<b>Application Ref:</b>	3/2025/0815			 Ribble Valley Borough Council www.ribblevalley.gov.uk
<b>Date Inspected:</b>	N/A	<b>Site Notice:</b>	N/A	
<b>Officer:</b>	EP			
<b>DELEGATED ITEM FILE REPORT:</b>				<b>APPROVAL</b>

<b>Development Description:</b>	Prior notification for proposed single storey rear extension with flat roof under Part 1 Class A of the GPDO. 4m long, 3m high (max) to ridge and 2.9m high to eaves.
<b>Site Address/Location:</b>	88 Mitton Road Whalley Clitheroe BB7 9JN.

TITLE: **Proposed Ground Floor & First Floor Plans and Elevations**
 Planning

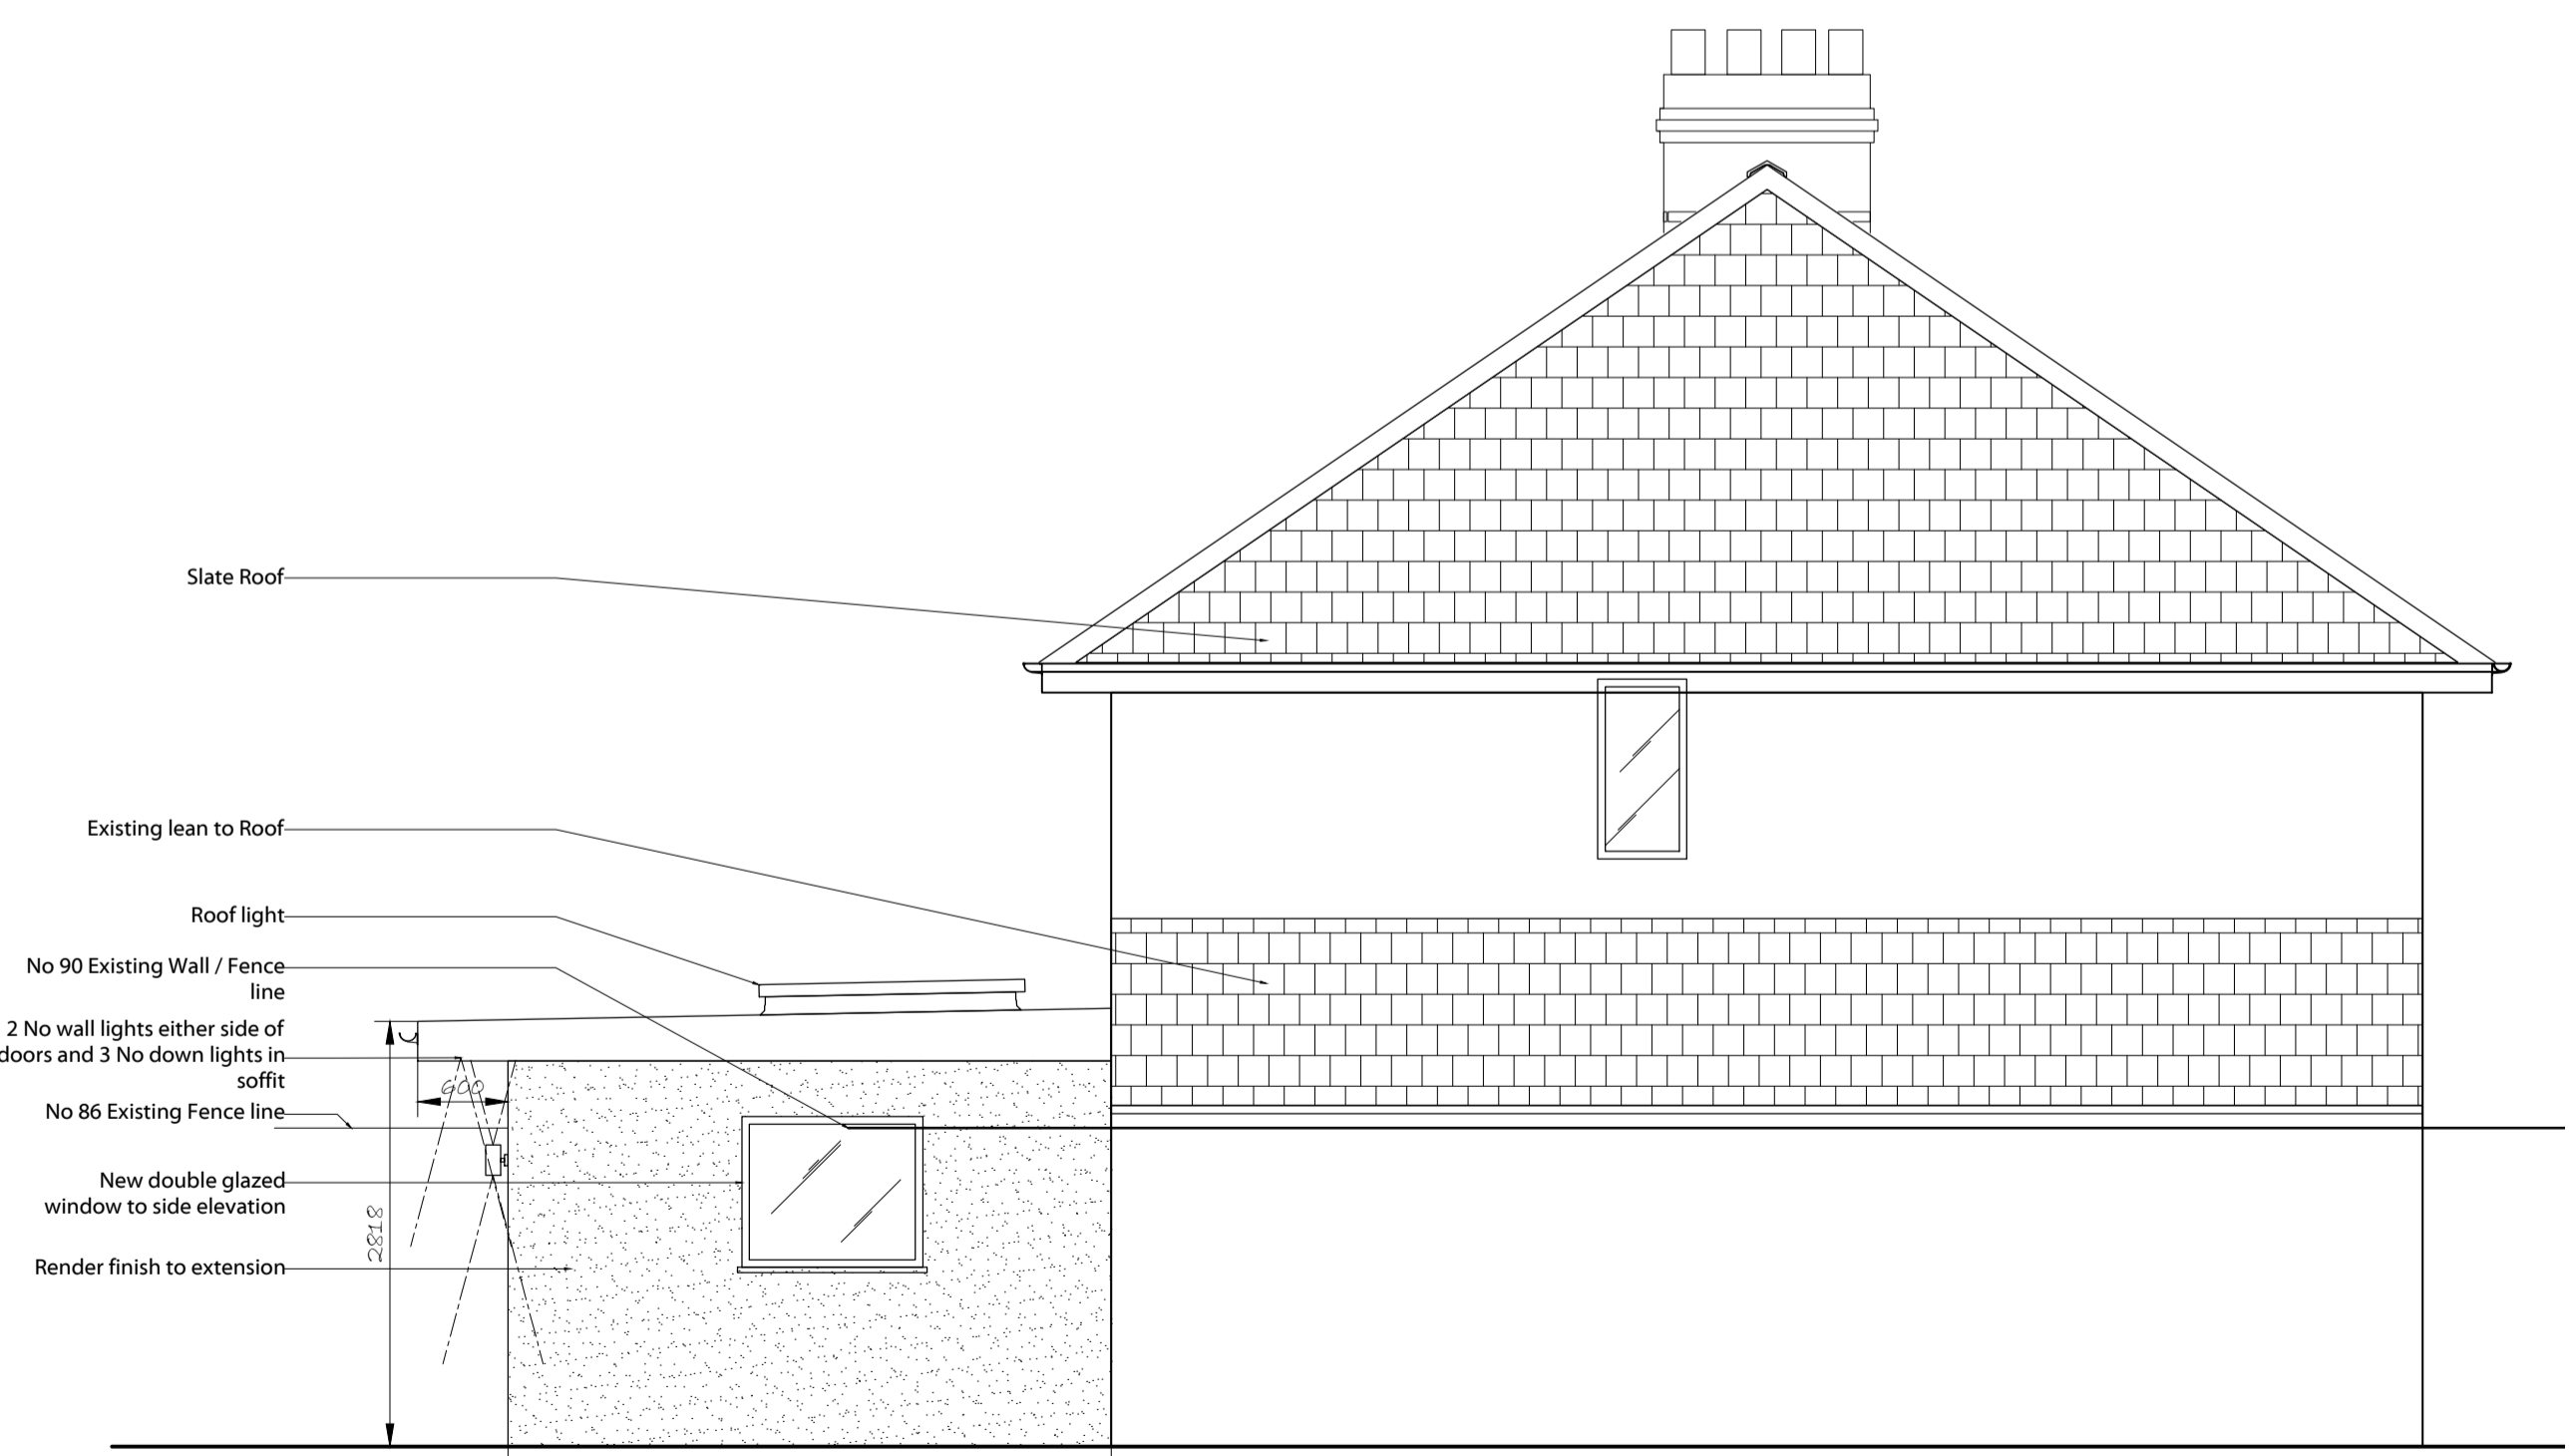
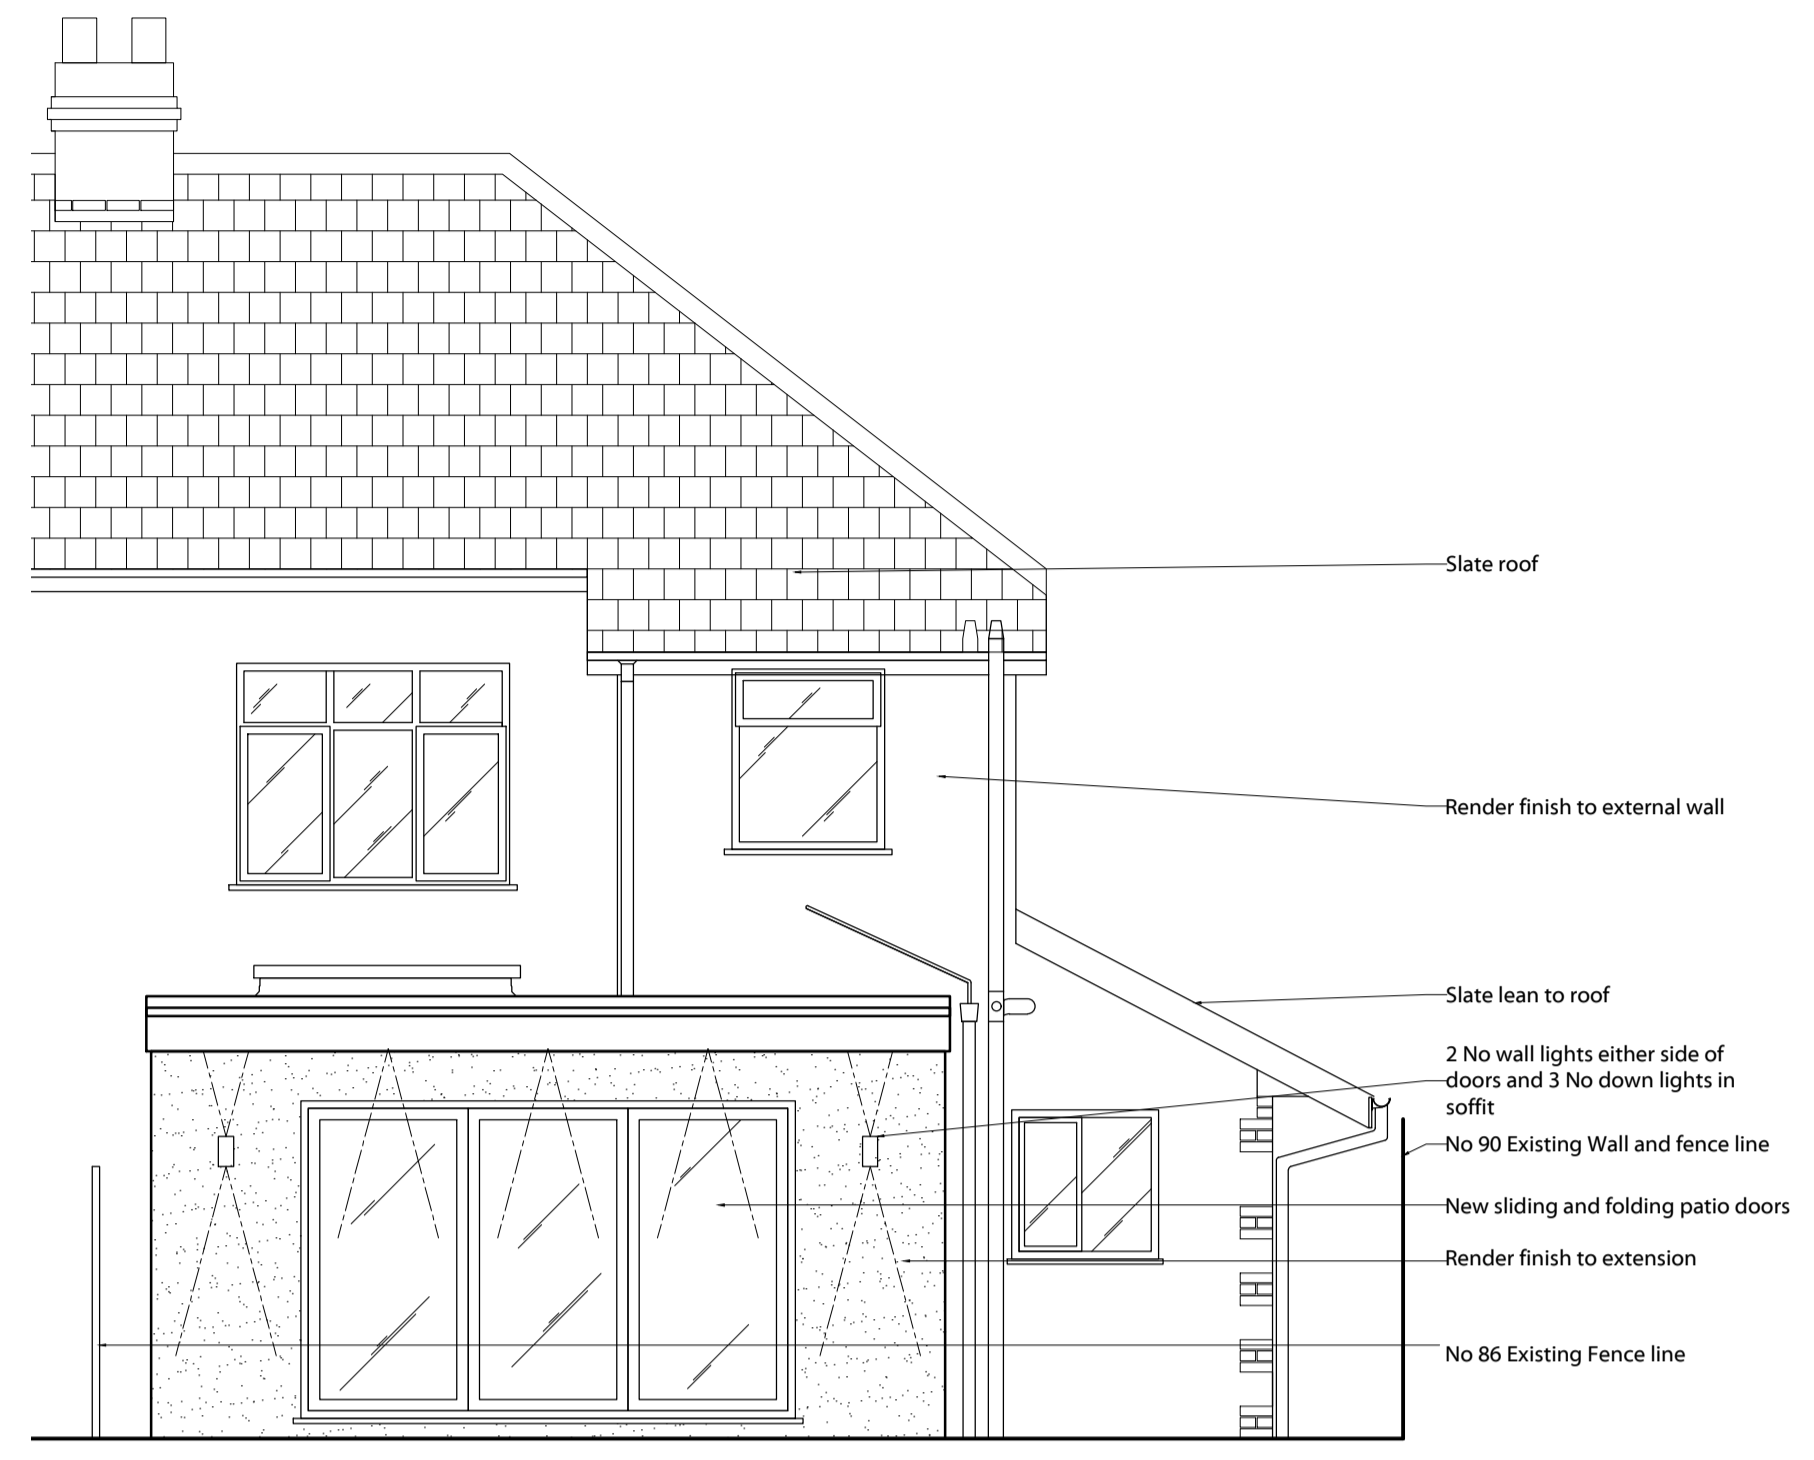
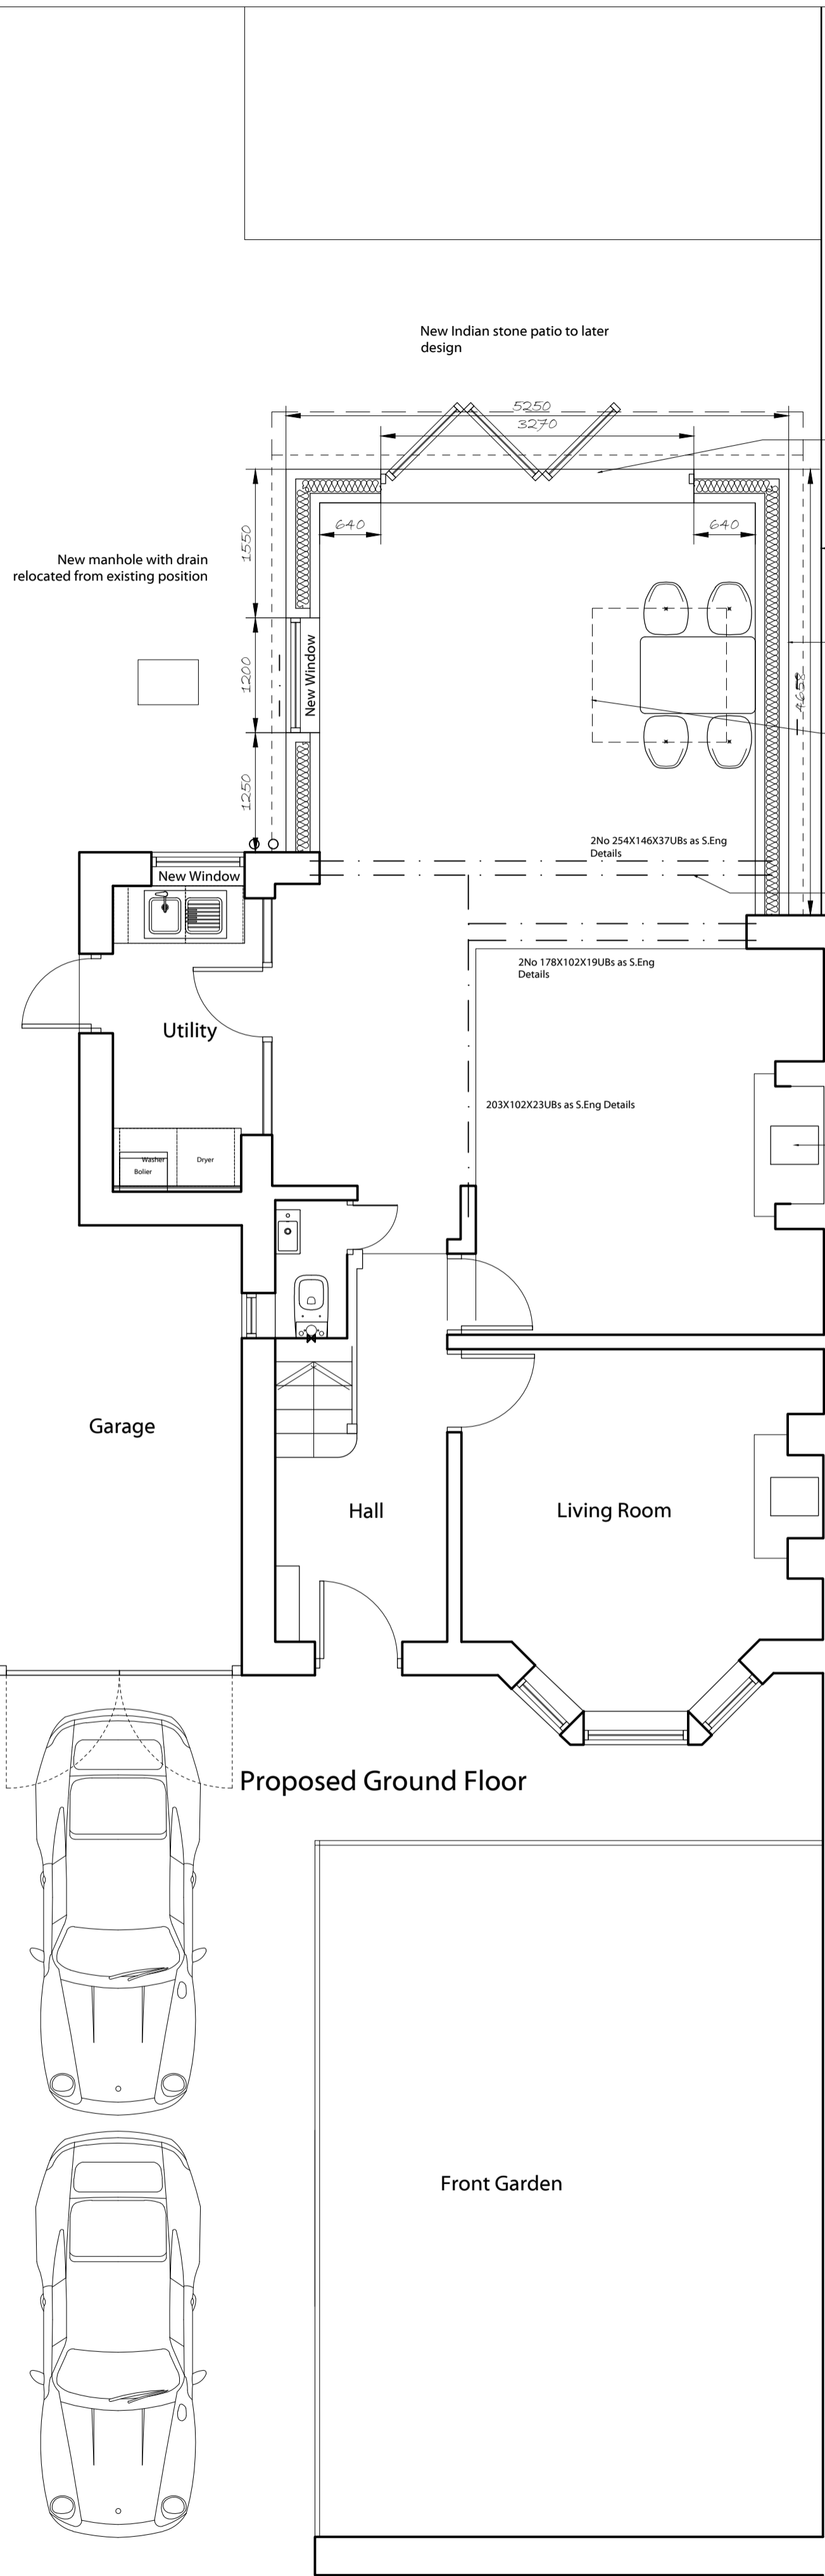
**The height of the proposed extension would not exceed the height of the existing dwelling.**

**The height of the eaves of the proposed extension would not exceed the height of the eaves of the existing dwellinghouse.**

**The proposed single storey extension would extend beyond the rear wall of the original dwellinghouse by 4.66 metres and measure 2.8 metres in height.**

**The proposed single storey extension would be sited within 2 metres of the boundary of the curtilage but will measure approximately 2.6 metres in height to the eaves.**

**The proposed materials are render to the elevations to match the existing dwelling.**
